Tel: 01903 737756
Email: planning@arun.gov.uk
www.arun.gov.uk/planning
Please ask for: Ms Ella Summerfield
Email: ella.summerfield@terraquest.co.uk
Telephone: 0121 2341390
Our Ref: FP/97/26/HH
Your Ref:
Date: 24th August 2026

Application for Planning Permission for Works or Extension to a Dwelling

Development: Single storey side and rear extension.
Location: 18 Ashmere Lane Felpham PO22 7QT

Drawing: Proposed Elevations.	
For: Penny & Jerry Spurr.	
Drawing Number: 1245.02.PI.	Revision: -
Scale: 1:50 @ A1.	Date: July 2026.

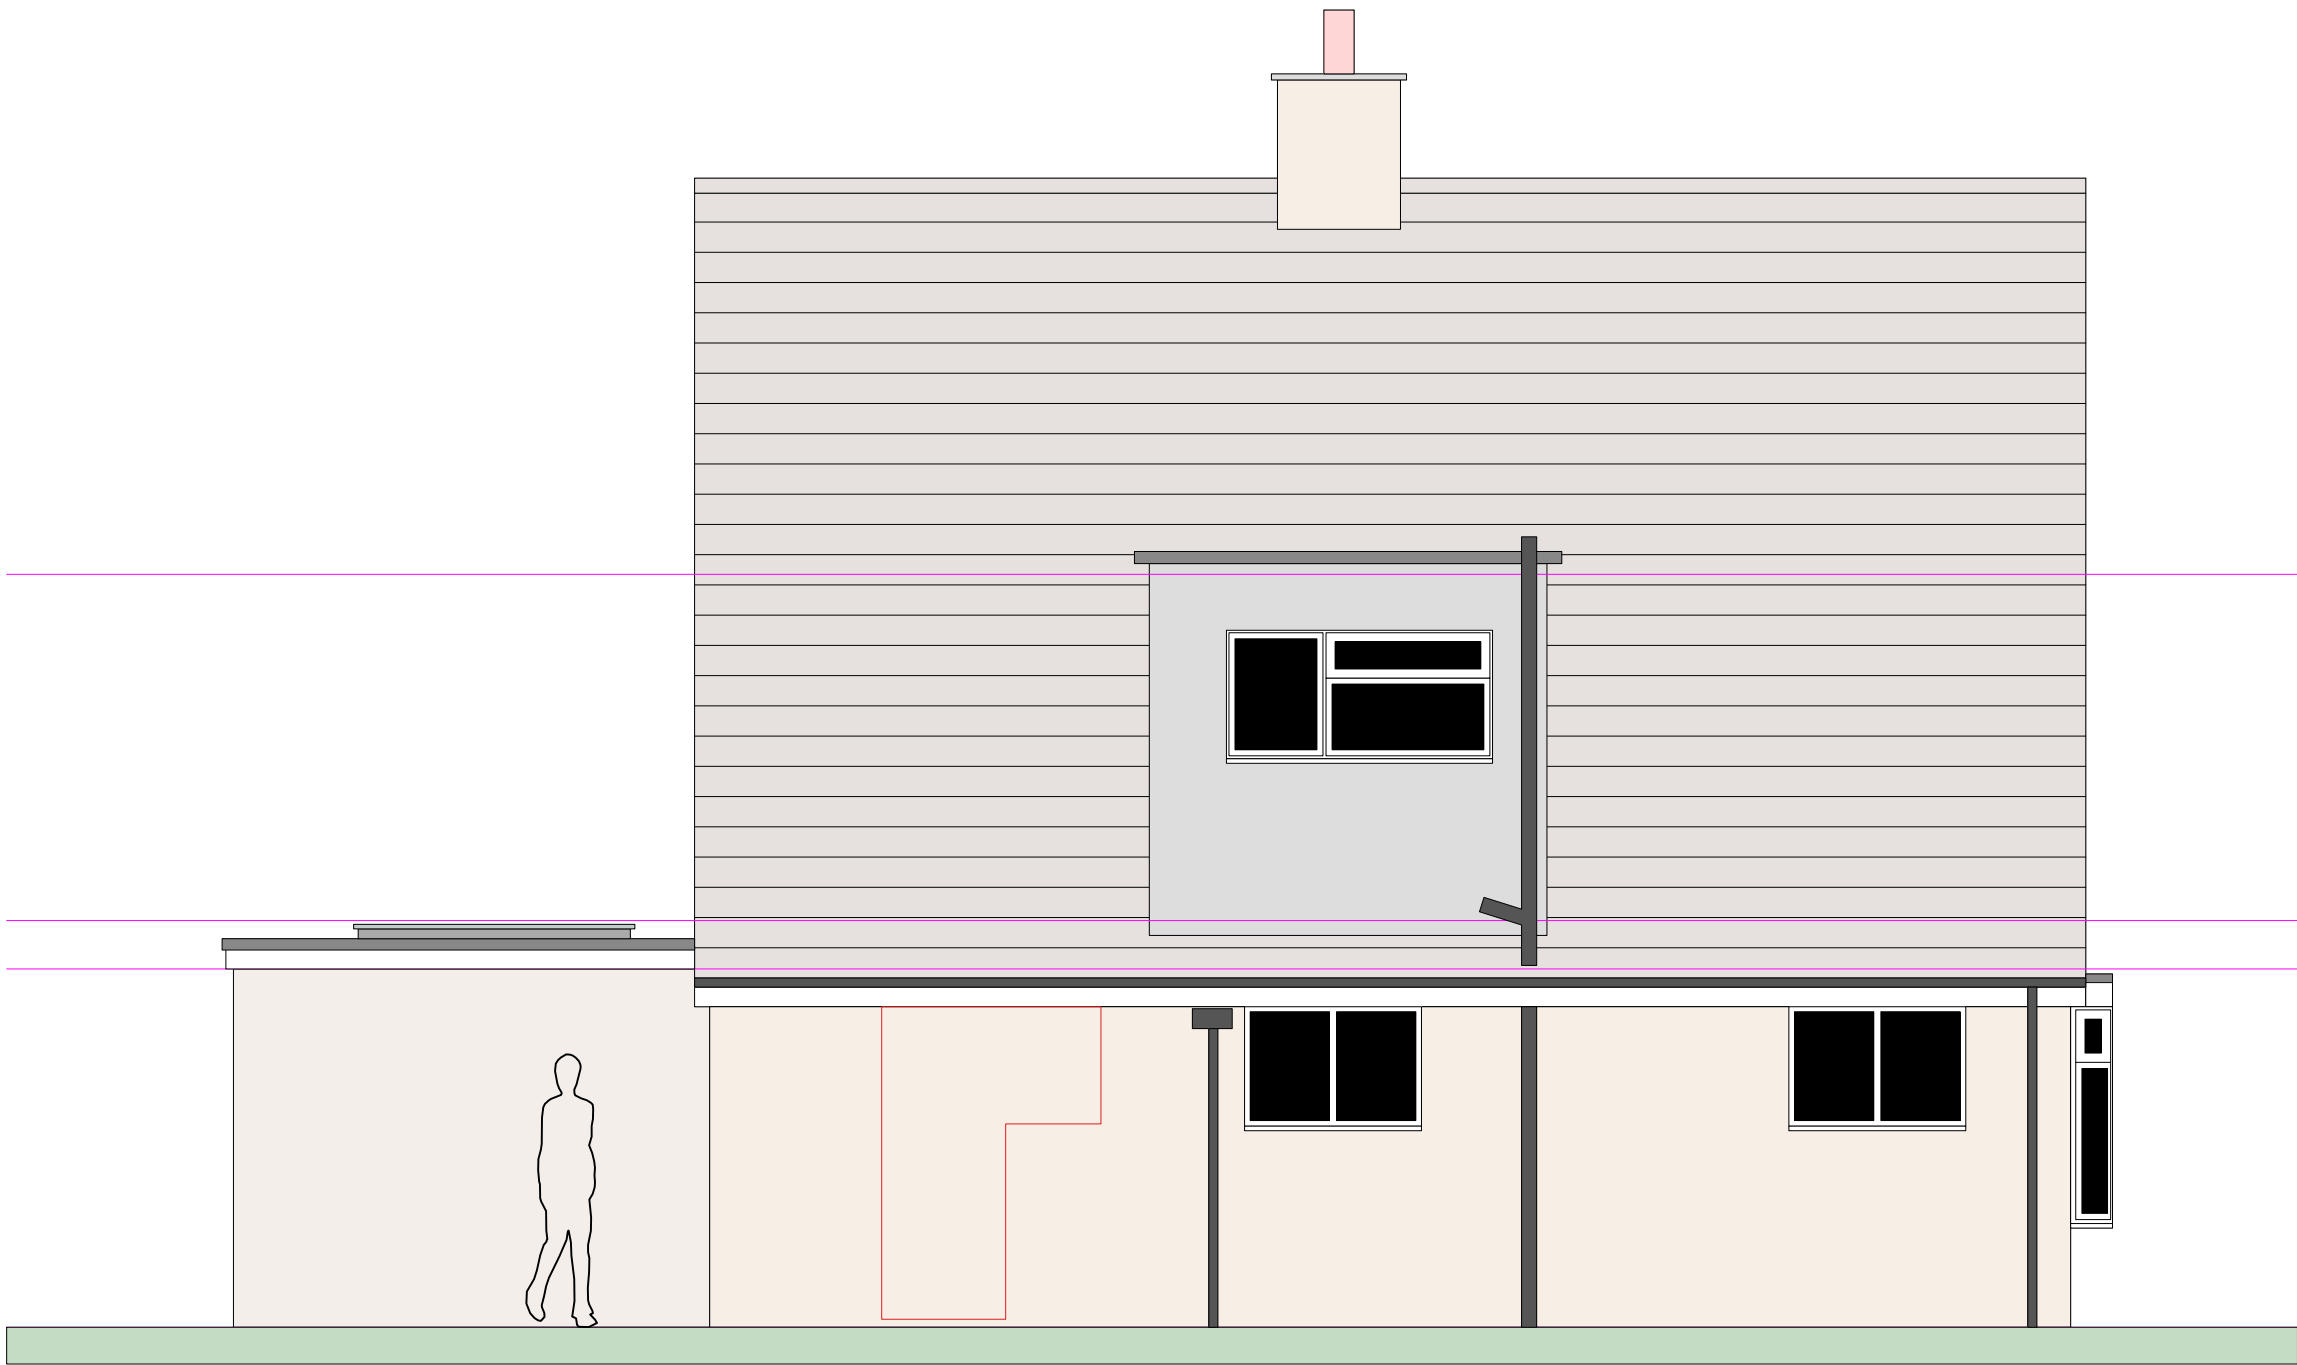
The existing south elevation floor plan window needs to be more clearly drawn as a window and the first floor north window.
